# KITITAS COUNTY

### MEMORANDUM

TO: All Staff  
FROM: Public Works Plan Review Team  
DATE: September 13, 2021  
SUBJECT: LPF-21-00009 Akehurst

AKEHURST PLAT
 A PORTION OF THE NW 1/4 OF SECTION 20, TOWNSHIP 18 NORTH, RANGE 19 EAST, W.M.,
 KITTITAS COUNTY, WASHINGTON

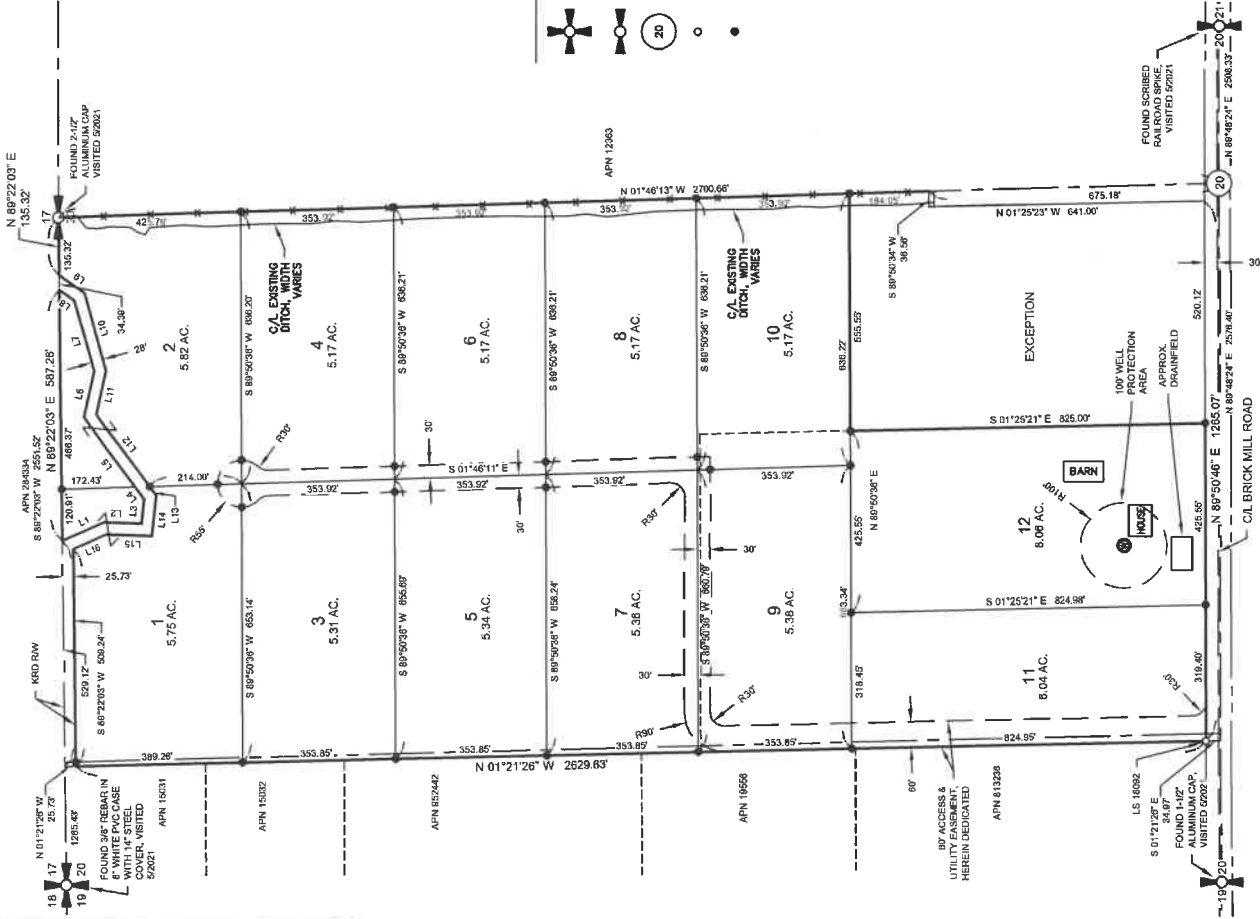
1. Submitted Plat is missing Surveyors Stamp.
2. The N'most Line of S portion of Lot 2 has the direction trimmed off.
3. The Basis of bearing statement is missing. This could be included in Survey Note 4.
4. Please include the total width, ownership and surfacing for Brick Mill Road.
